Project #: 1001770	70152
Project Name: LANDS OF JOEL P TAYLOR	
Agent: CONSENSUS PLANNING Phone #:	
Your request was approved on \(\sum_{\text{L}} \sum_{\text{L}} \) by the DRB with delegation of signature(s) to the following departments - outstanding comments to be addressed)
ETRANSPORTATION: Gd Ness compress

May 19, 2014

RE: project 1001770, 14EPC-40007 and 14EPC-40008

**WEST ELEVATION** ①  
 SCALE: 1/4"=1'-0"

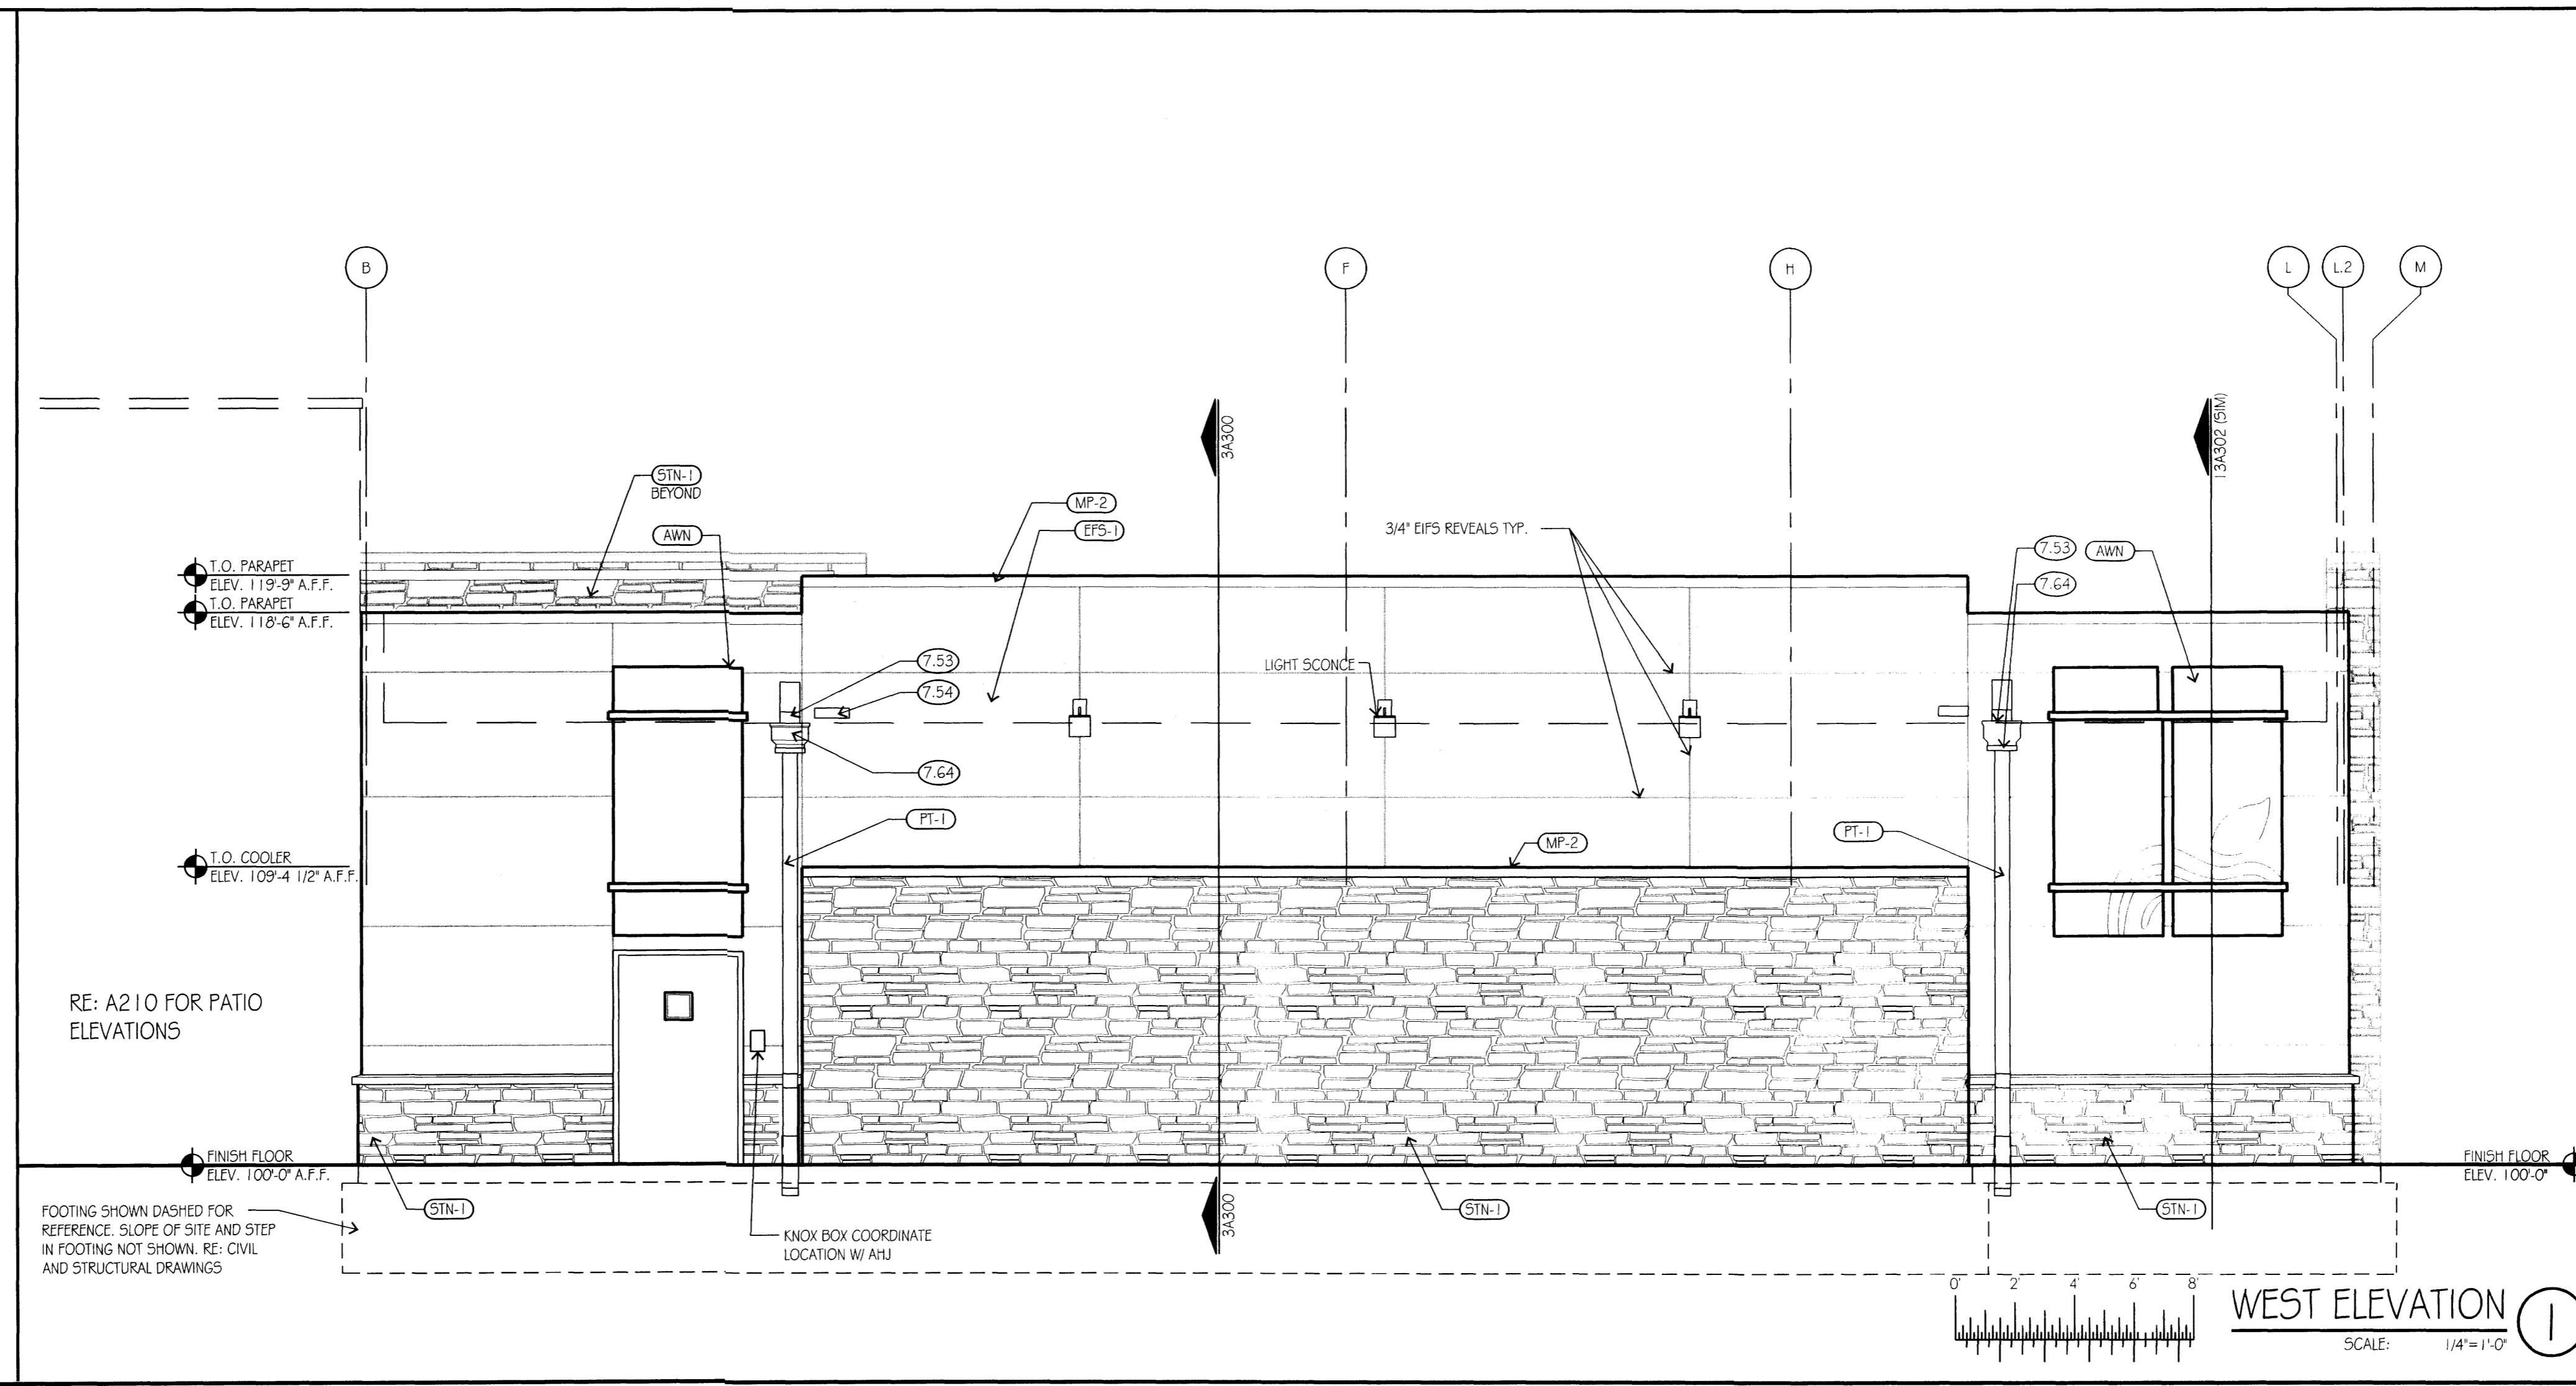
- 9. The applicant will work with staff to add architectural features and/or landscaping to break up the blank wall of the west elevation that faces Coors Blvd. The applicant has revised the west elevation and added both landscaping and architectural features. The new design meets the requirements of this condition.

**VIEW MASSING ANALYSIS**

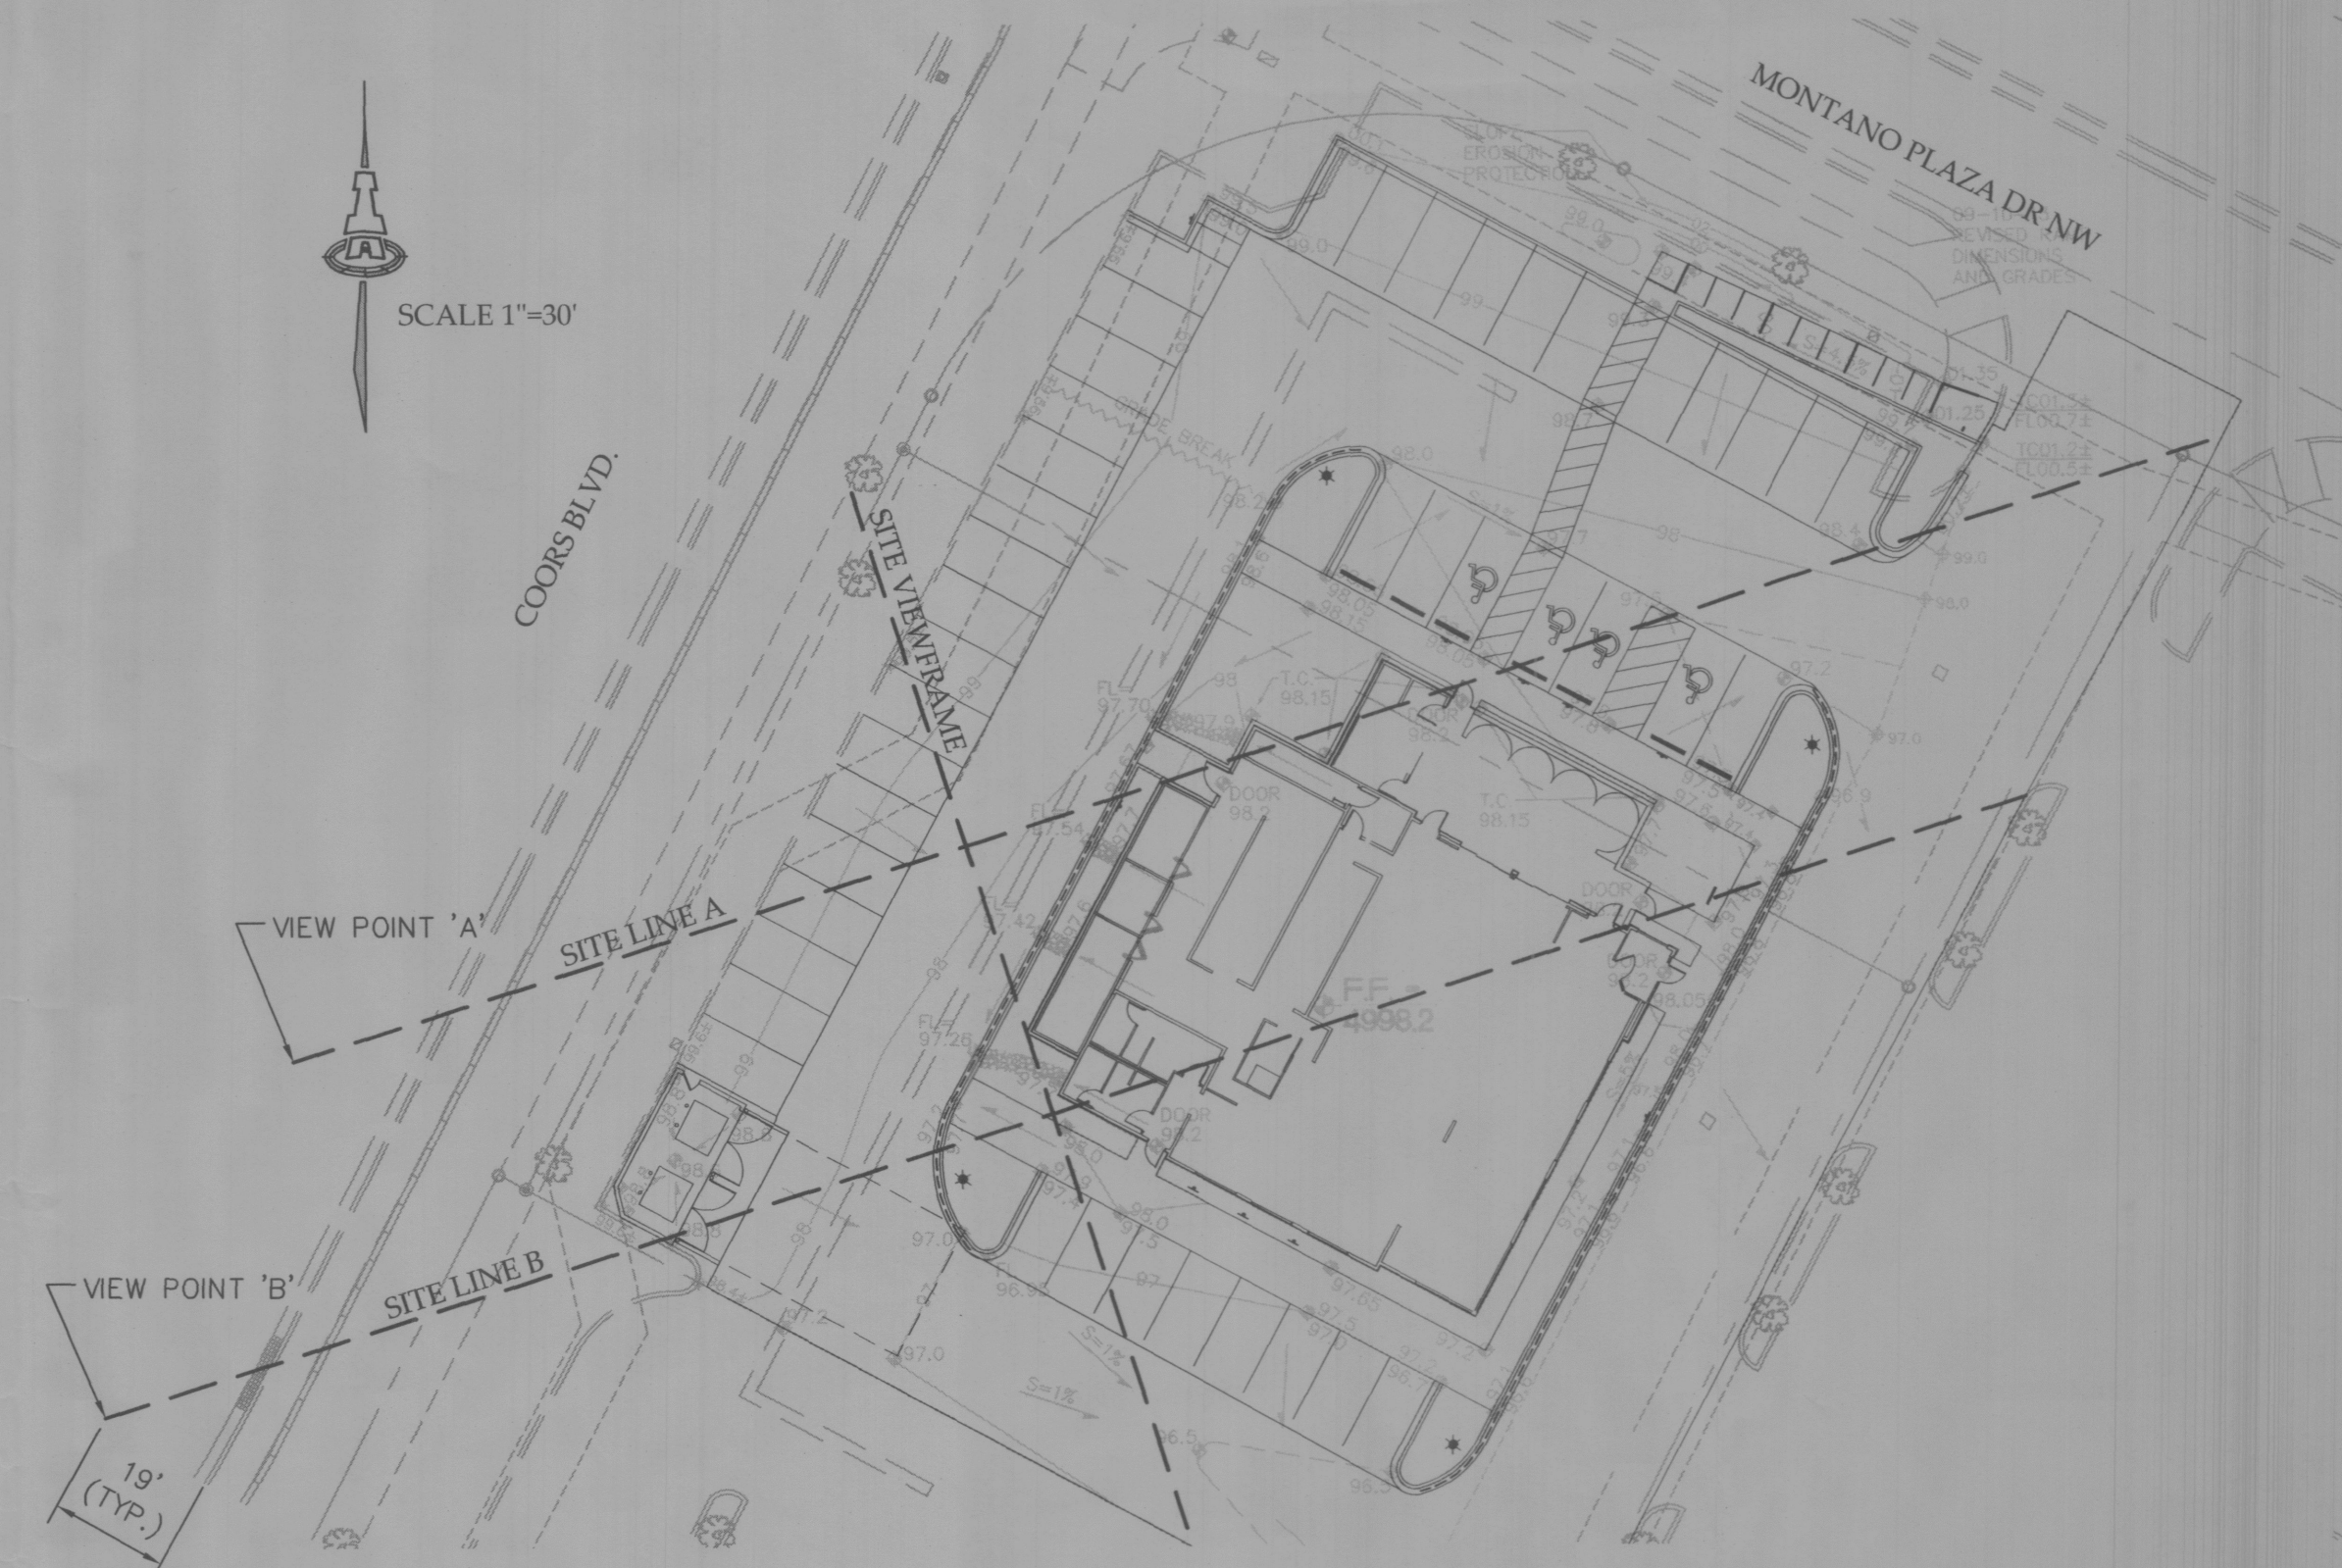
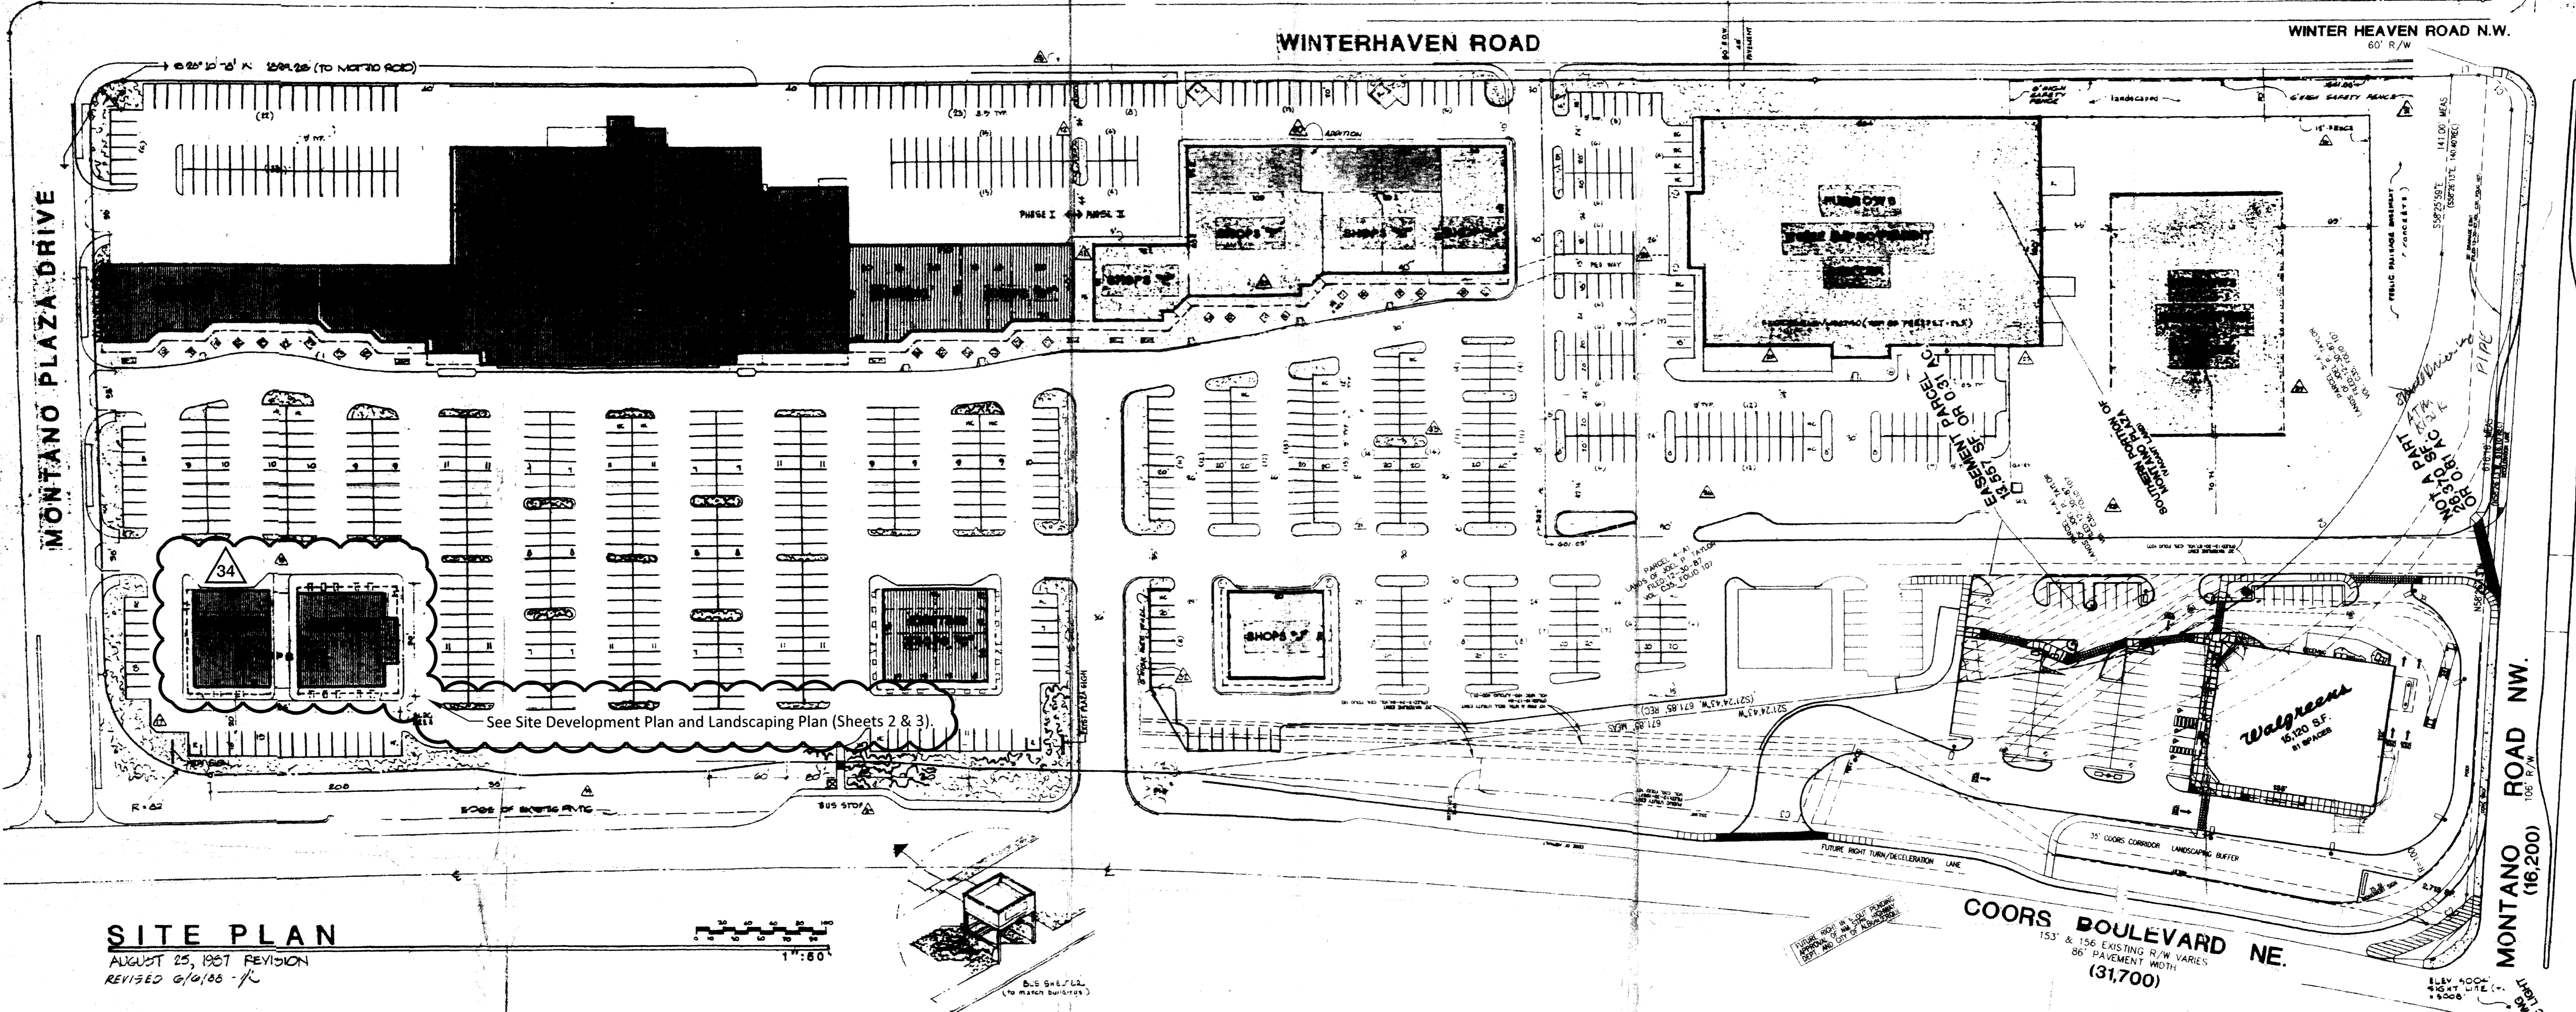
Staff agreed that the conditions had been met except that the required massing exhibit was not clear. The applicant was asked to revise this exhibit before submitting to DRB. The DRB submittal dated May 6th contains an updated massing exhibit that is clear and shows that the proposed building does not block more that 50% of the view area per the Coors Corridor plan.

- 10. The building height, except the elevator tower, shall comply with the view frame as defined in the Coors Corridor Plan and will be verified by staff prior to DRB sign-off.

The applicant submitted a revised massing exhibit that shows compliance with the view frame as defined in the Coors Corridor Plan and meets this condition.
- 11. The building massing, including the elevator tower shall comply with the view frame as defined in the Coors Corridor Plan and will be verified by staff prior to DRB Signoff. *See condition 10.*
- 12. The elevator tower height and massing is approved as shown and dimensioned on the building elevation sheets dated March 11th, 2014. The elevator tower is shown on this submittal as it was on the March 14th submittal. The condition is met.
